**KIRKLEES METROPOLITAN COUNCIL  
INVESTMENT & REGENERATION SERVICE**

**DELEGATED DECISION TO DETERMINE PLANNING APPLICATIONS**

| Reference No:         | <b>2022/62/93963/E</b>                          |
| Description:          | Erection of dormer windows to front and rear    |

PROJECT NAME 32 Walnut lane WF12 8NJ			
DRAWING TITLE Proposed Floor Plans & Elevation		DRAWN BY/ CHECKED BY MR/SM	
PHASE	SCALE	SHEET NO.	PROJ.NO.
Planning Application	1:100 @ A3	AR-03	C22076

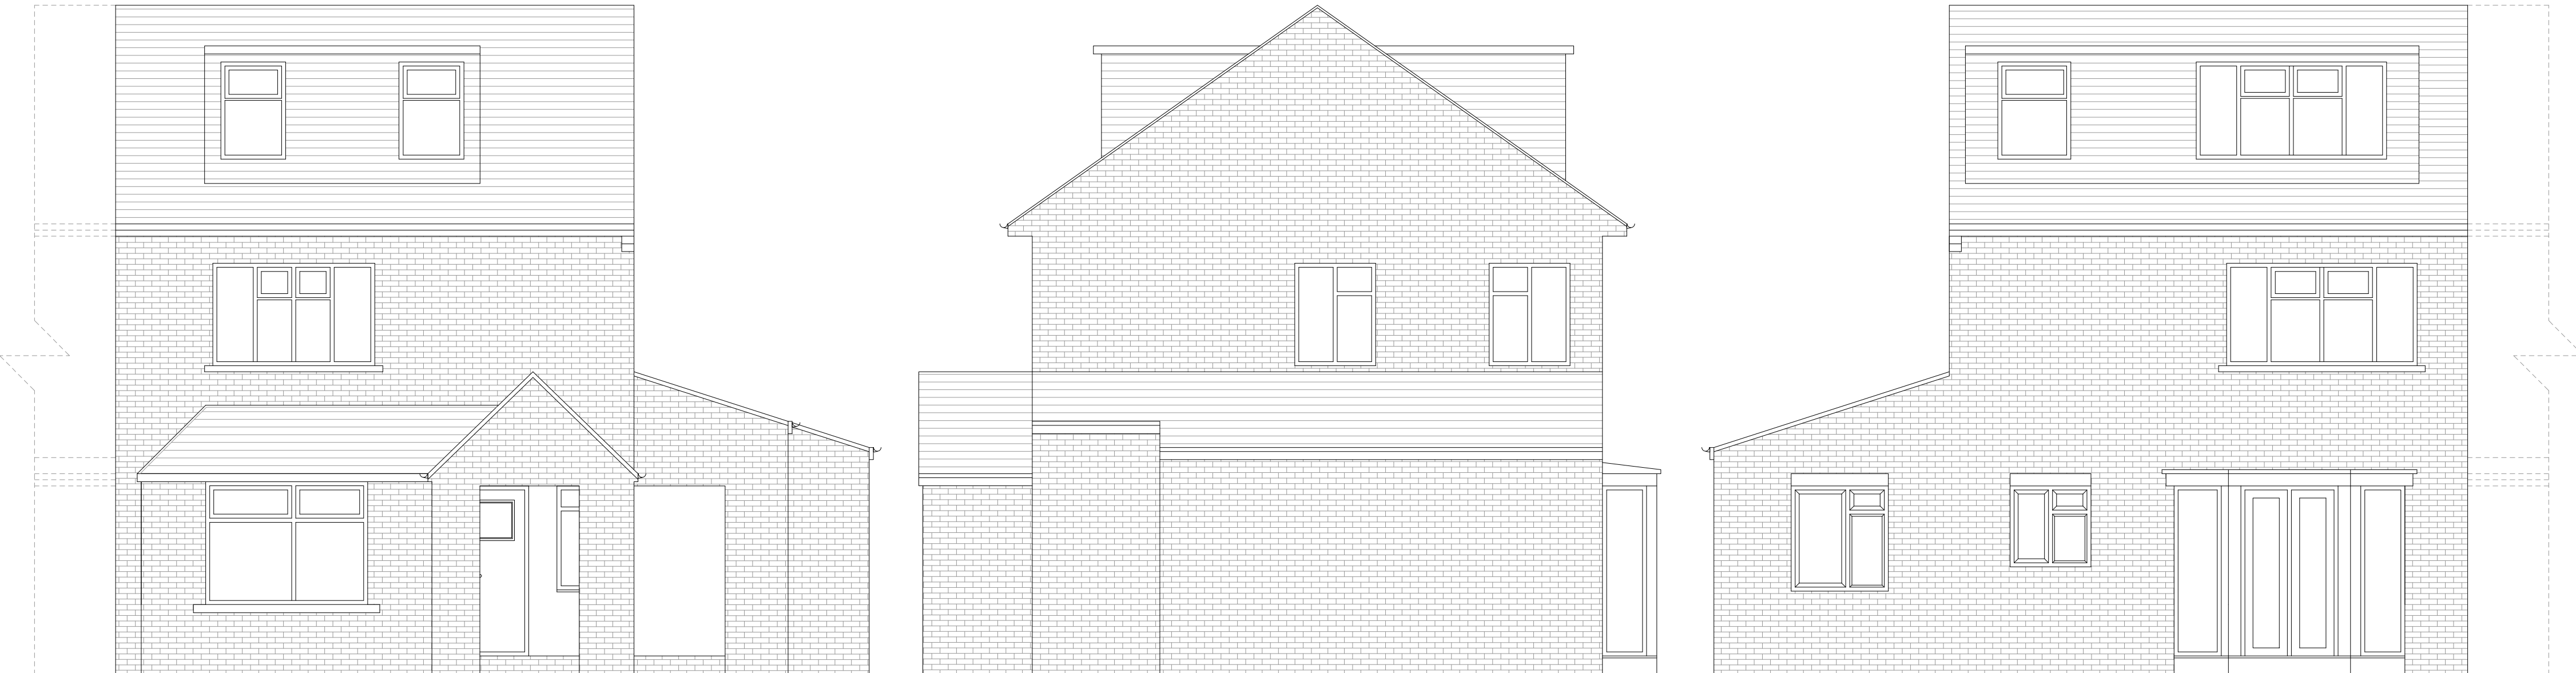
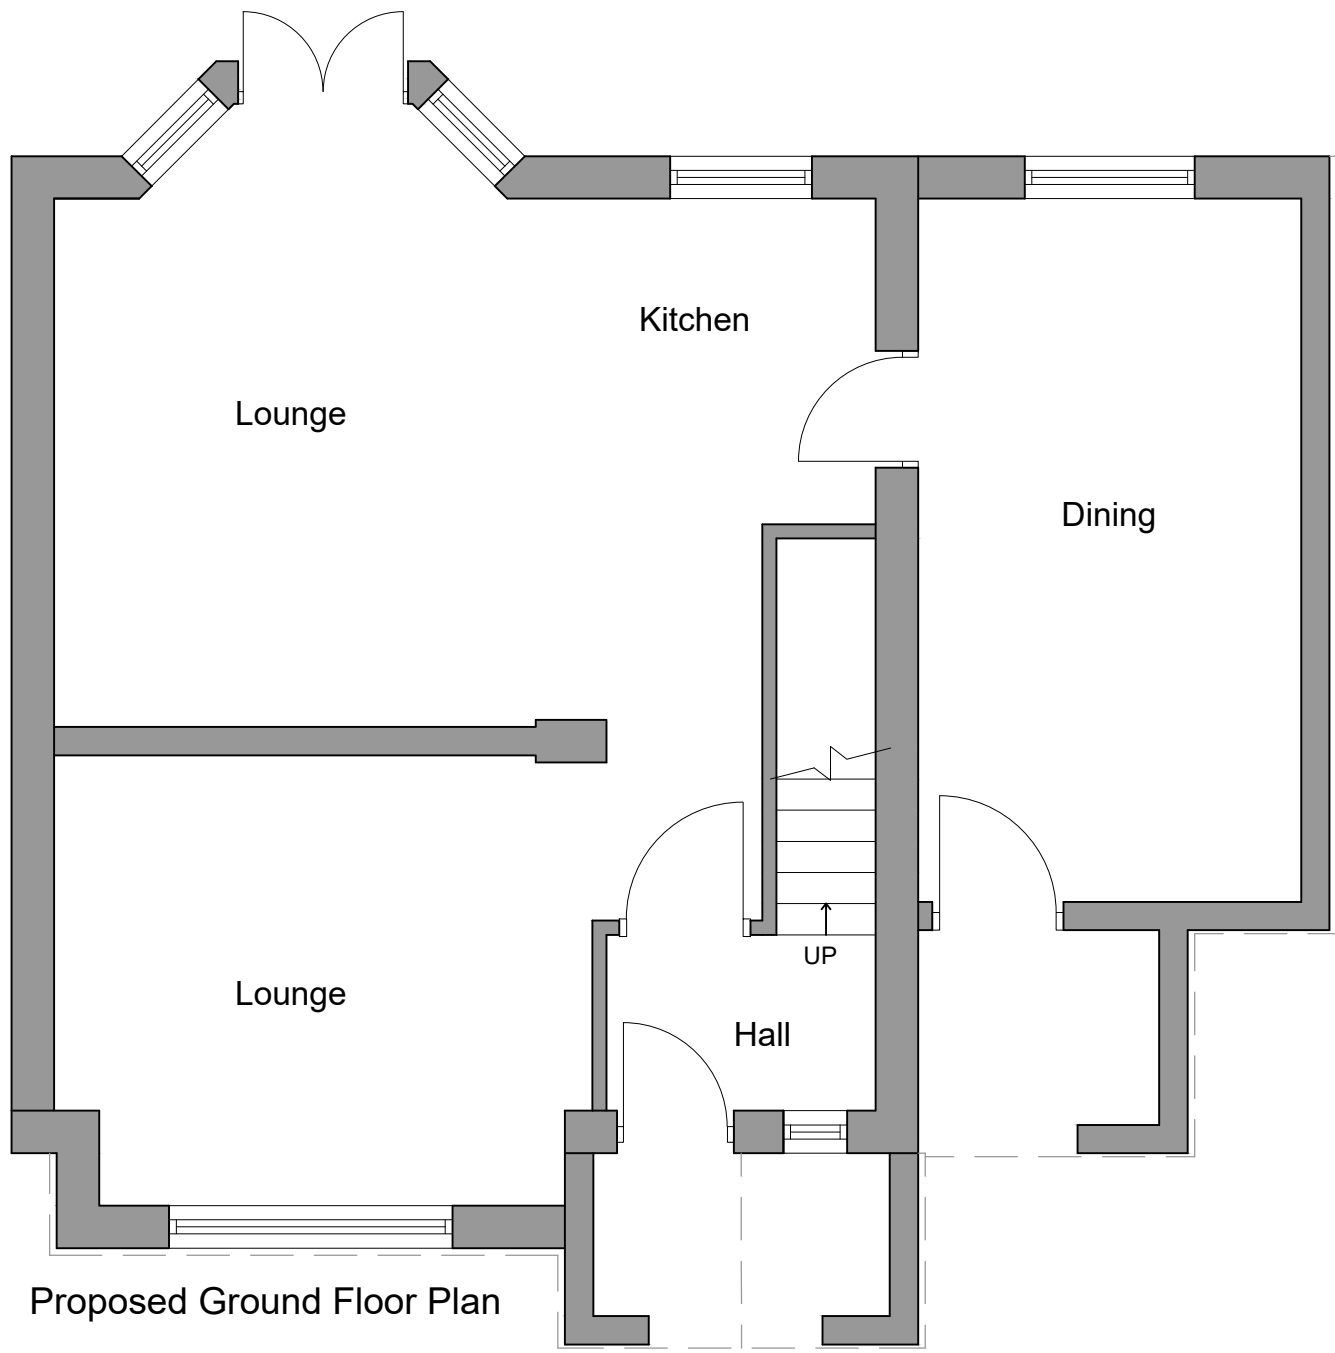
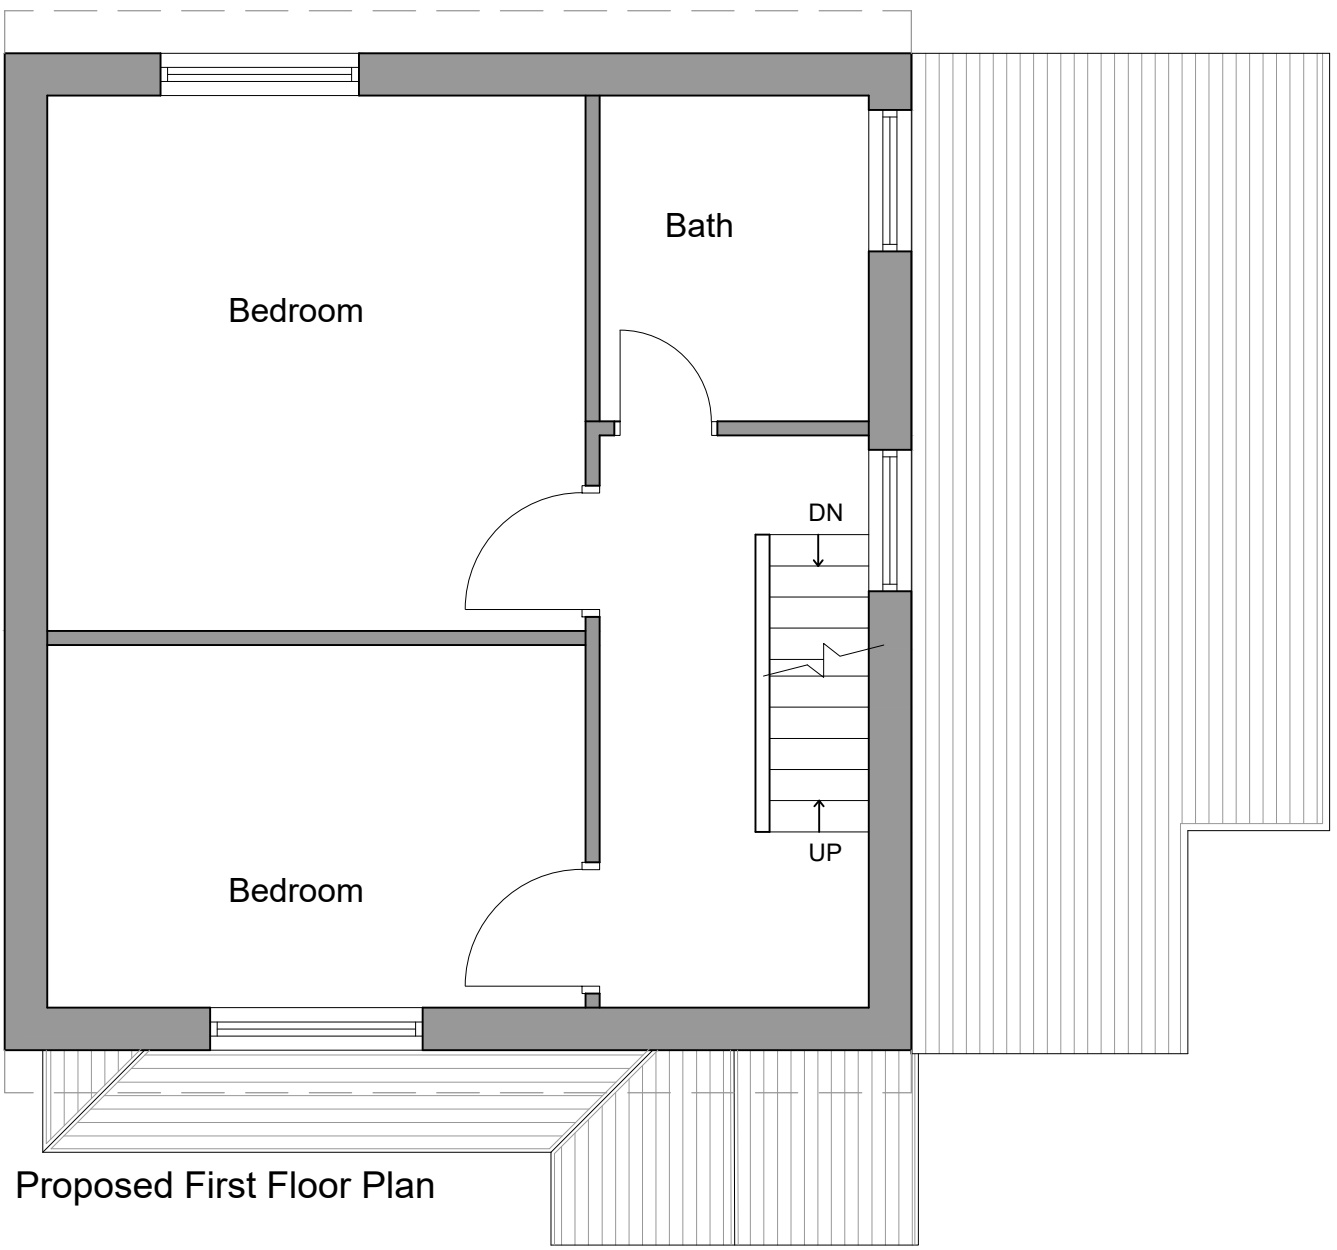
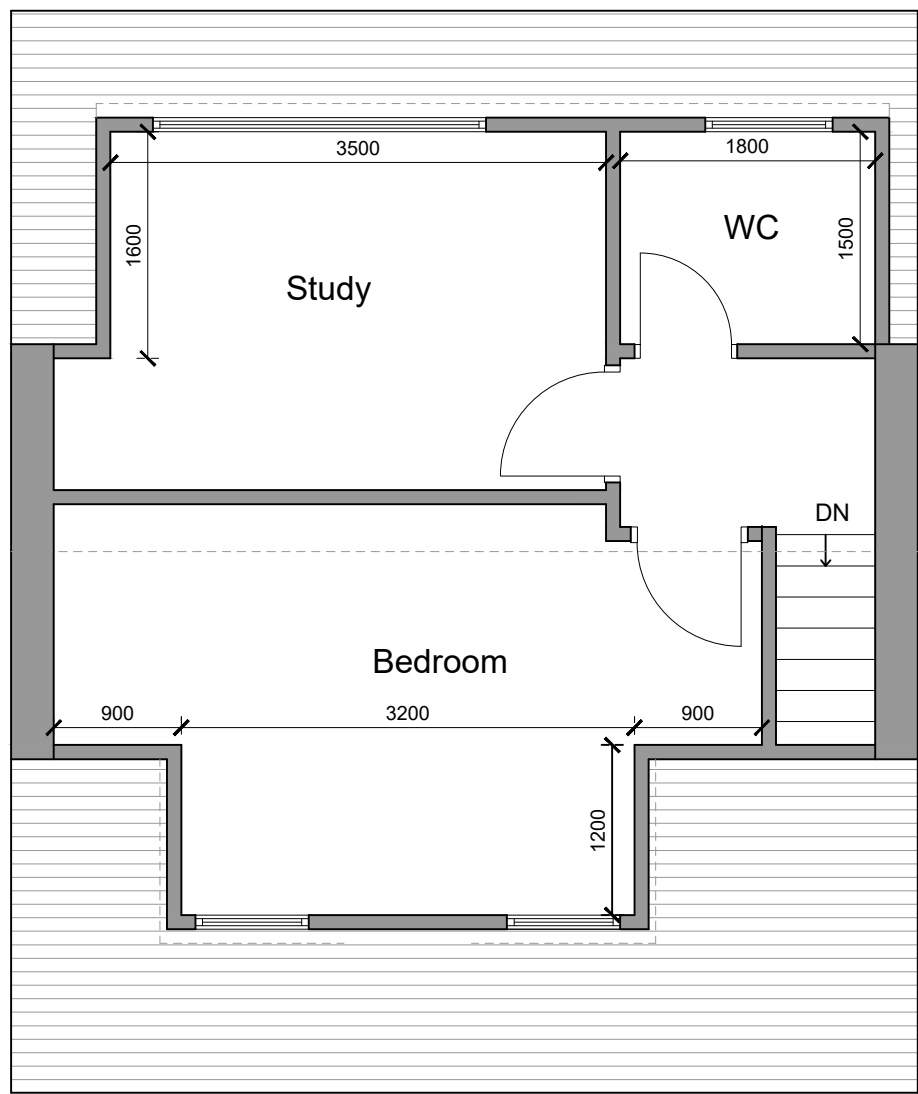
The application seeks planning permission for the erection of front and rear dormer extensions. The proposed rear dormer extension would have a width of approx. 5.25m, a depth of approx. 2.2m and a maximum height of approx. 1.6m. Furthermore, the proposed front dormer extension would have a width of approx. 19m, a depth of approx. 1.83m and a maximum height of approx. 1.6m.

The proposed dormer windows would be located within the front and rear roof planes and would be faced in grey concrete interlocking tiles to match the appearance of the original dwellinghouse. The dormer extensions would be set back from the eaves line and sited below the existing ridge height. The dormer windows would also be of an appropriate size and design and would generally align with the existing fenestration. Whilst it is noted that the area is generally devoid of dormer extensions, in this instance, the dormers are considered acceptable given the lack of uniformity within the street scene. On this basis, the proposed development would not have any significant visual impact on the character and appearance of the host property and surrounding area and would be acceptable in this regard.

neighbouring properties would occupy a position approximately 37m from the proposed rear dormer extension. Given that the separation distance retained would be sufficient, it is considered that there would be no overbearing impact, overshadowing or overlooking of the adjacent occupant's amenity as a result of the proposed works.

The plans also confirm that the proposed front dormer extension would occupy a position approximately 110m from the front elevation of 29 Walnut Lane. Given that the separation distance retained would be substantial, it is considered that there would be no undue harm to the neighbouring occupants with regard to overlooking.
